**Our Ref: M/91/11/
Your Ref:**

Please ask for:
Mrs D Johnson
(01903) 737500 Ext 37762
2nd November 2011

**Extension to lower roof to form 2 bedrooms
2 West Close Middleton on Sea**

Existing Side Elevation

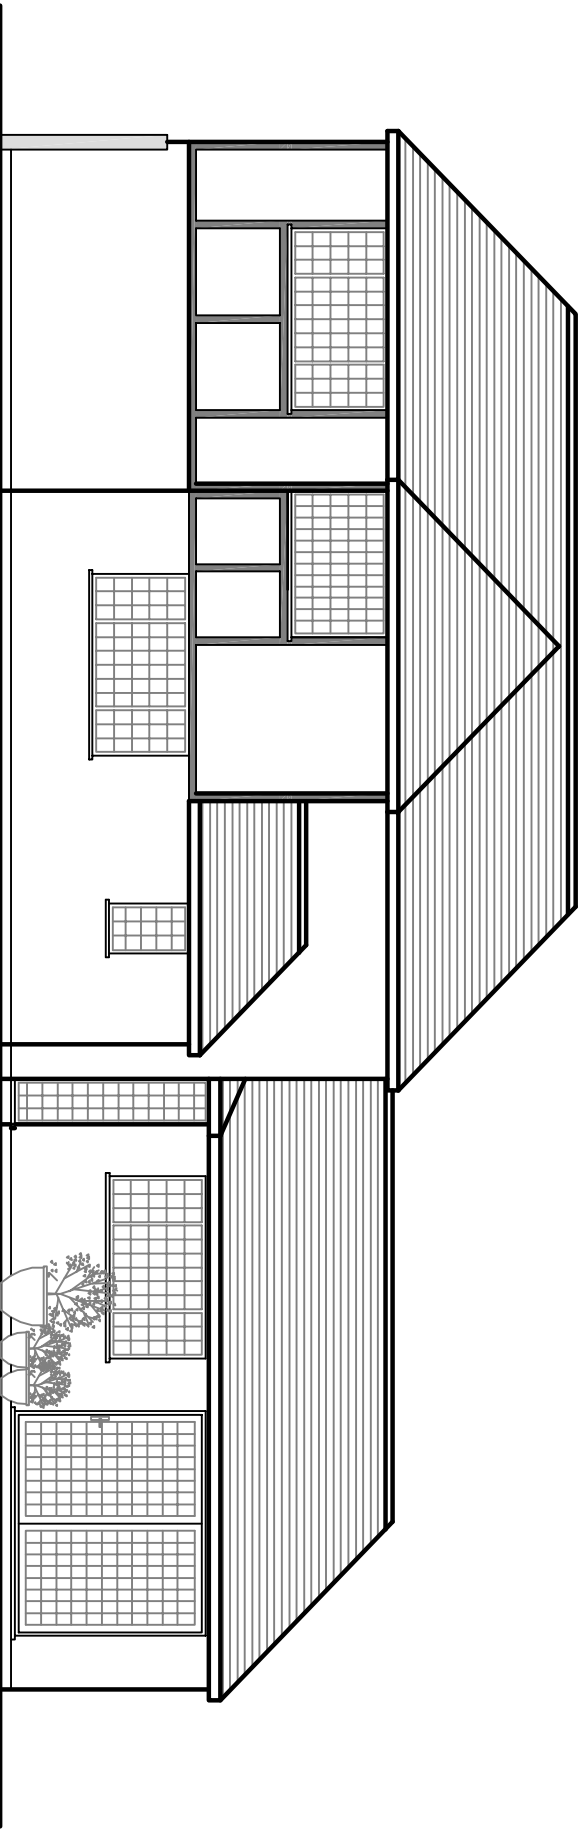
The existing first floor plan does not accord with the existing side elevation. Please amend accordingly.

Proposed Side Elevation

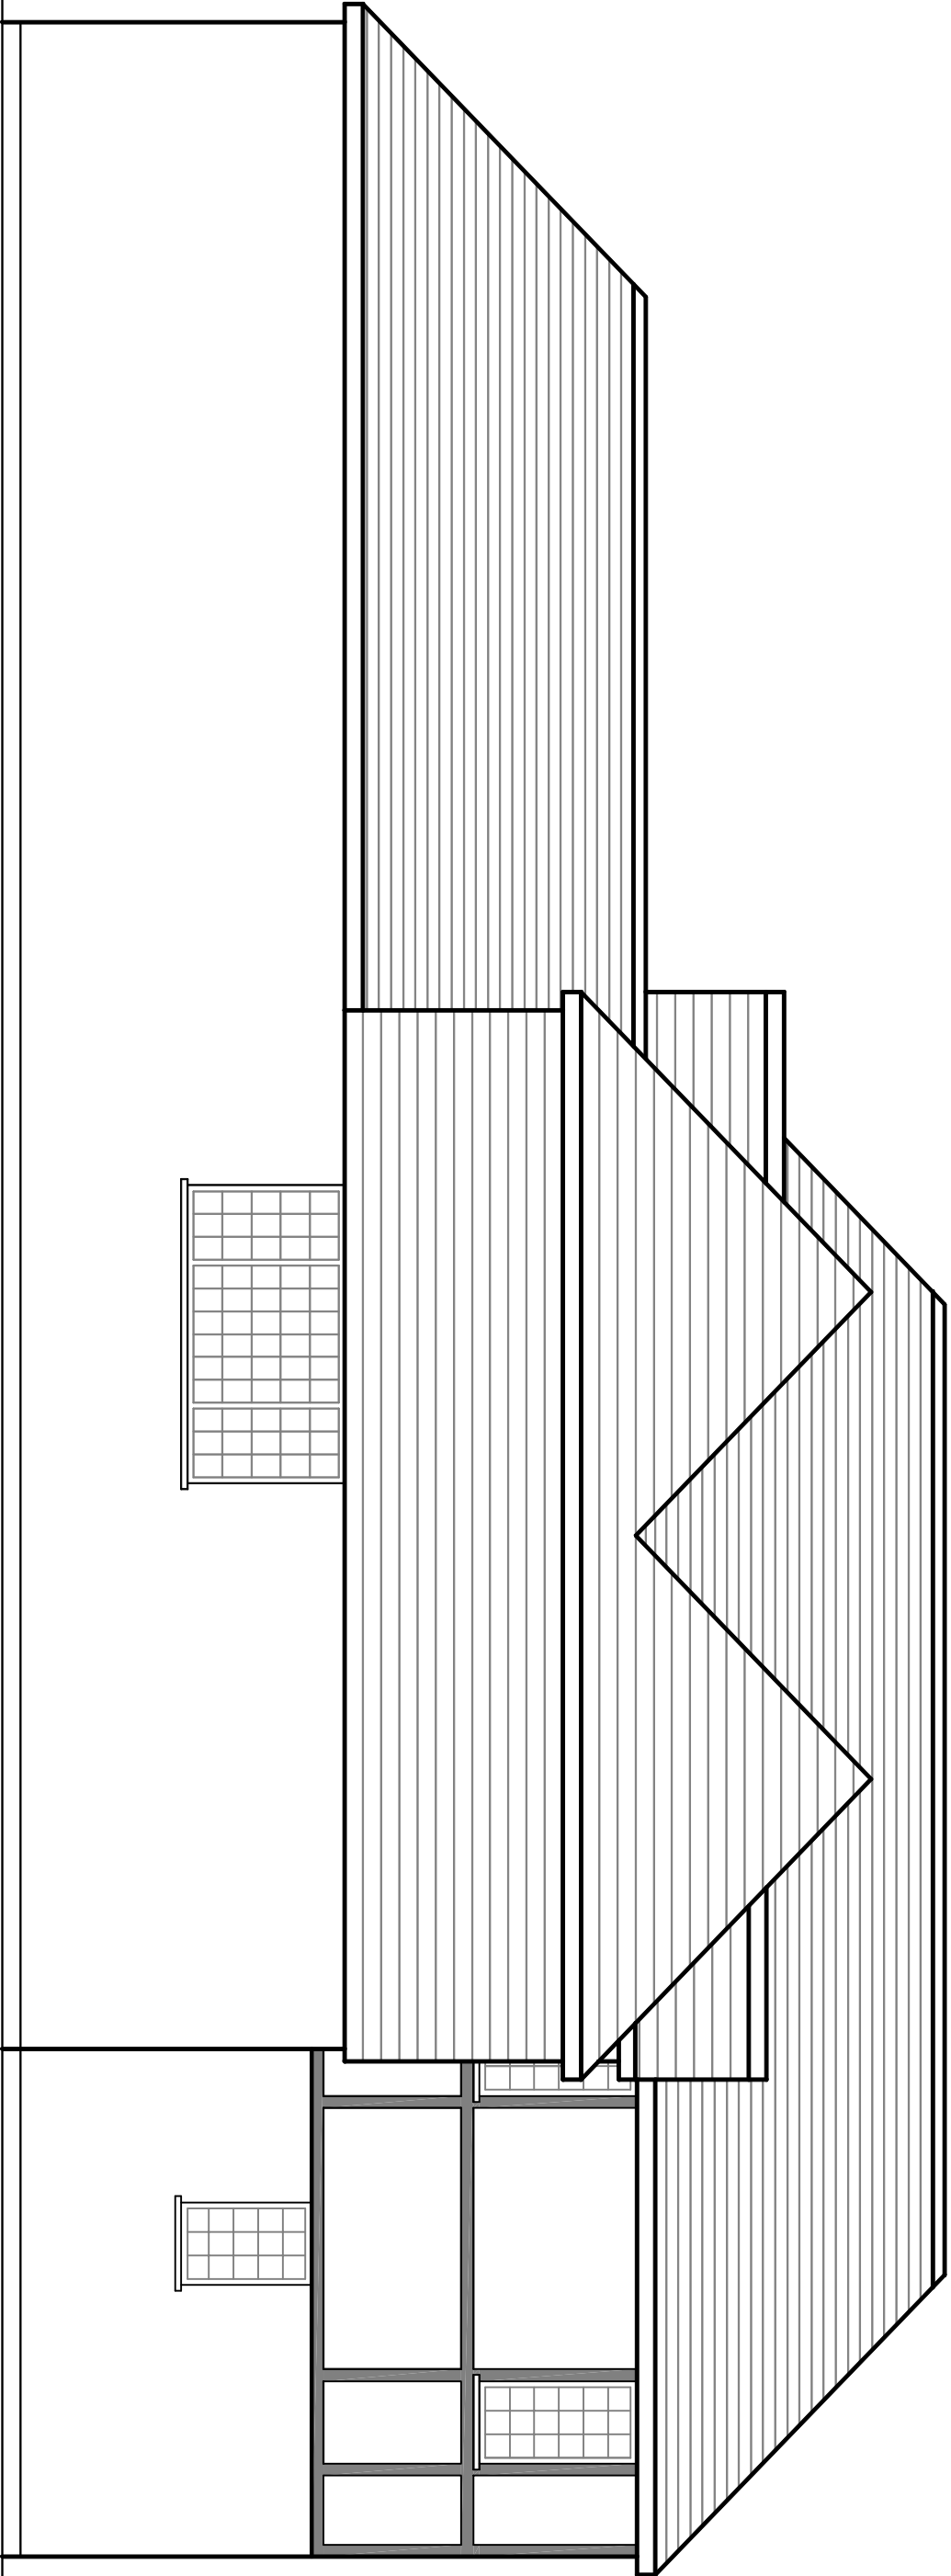
The proposed first floor plan does not accord with either of the proposed side elevations. Please amend accordingly.
